**North Kellyville Public School, 120-126 Hezlett Road, Kellyville (SSD 8344)  
Notice of Exhibition**

## **TAB A – Detailed Comments on State Significant Development Application**

Re: Hezlett Road, Kellyville – Linemarking and signposting plans for North Kellyville PS

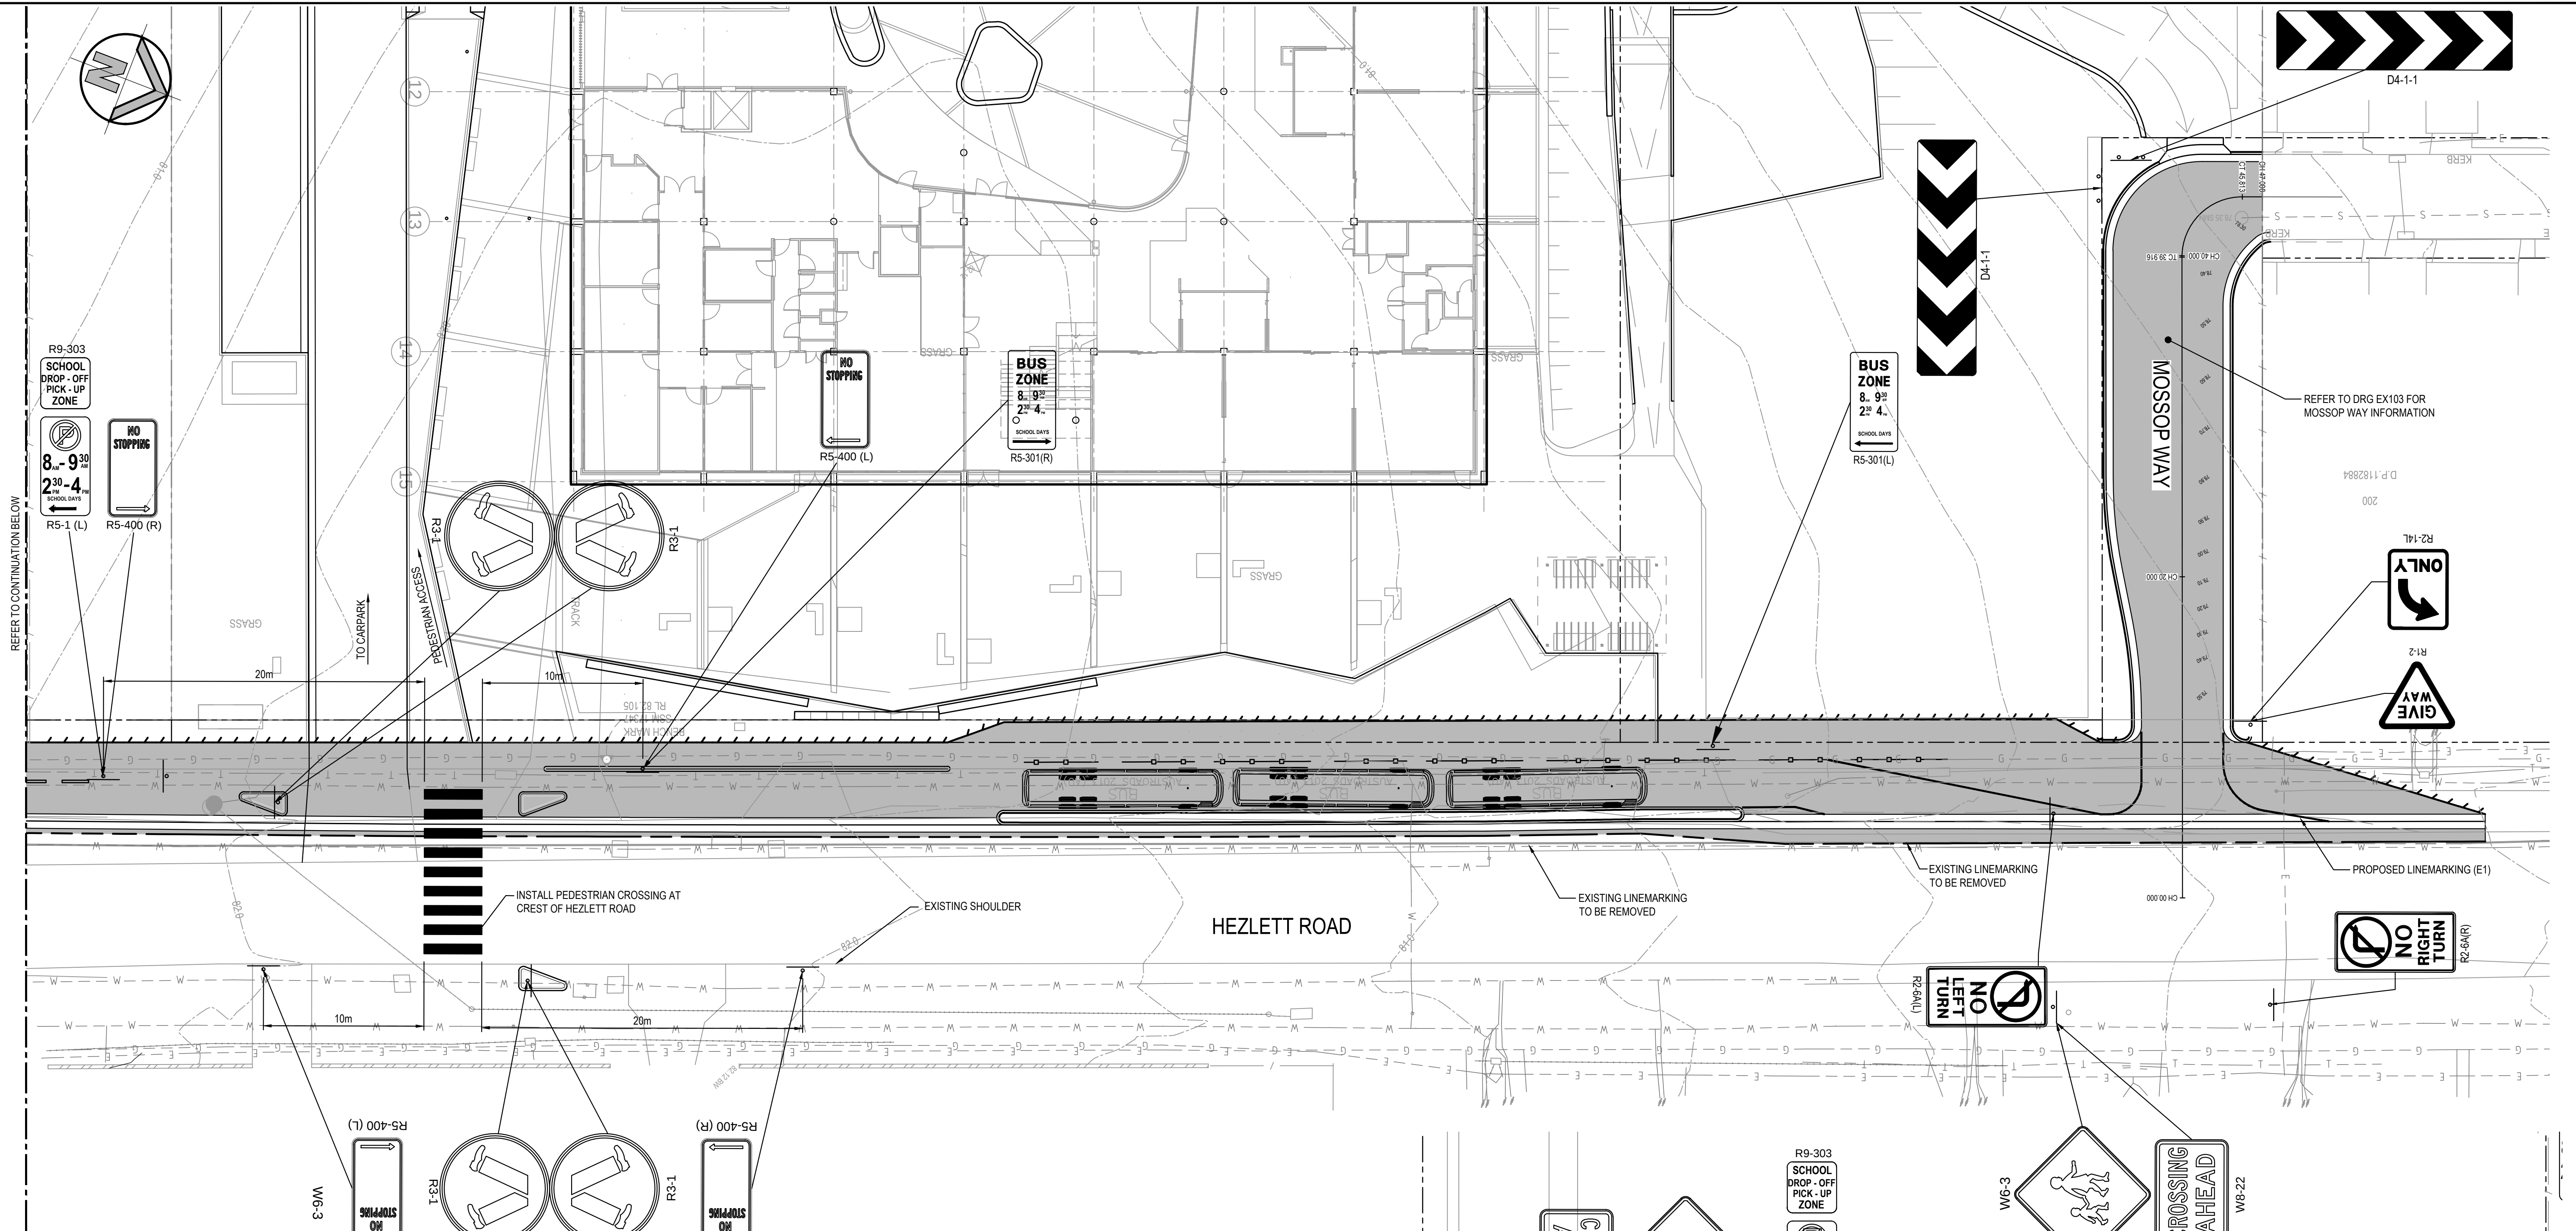
- The EIS should provide a concept plan for the signage and linemarking required to accommodate pick-up/drop-off, bus layover and any other traffic or parking control devices.

Furthermore, the EIS should provide a concept plan for the signage and linemarking required to accommodate pick-up/drop-off, bus layover and any other traffic or parking control devices. The bus zone should only be in operation for the morning and afternoon school pick-up/drop-off periods.
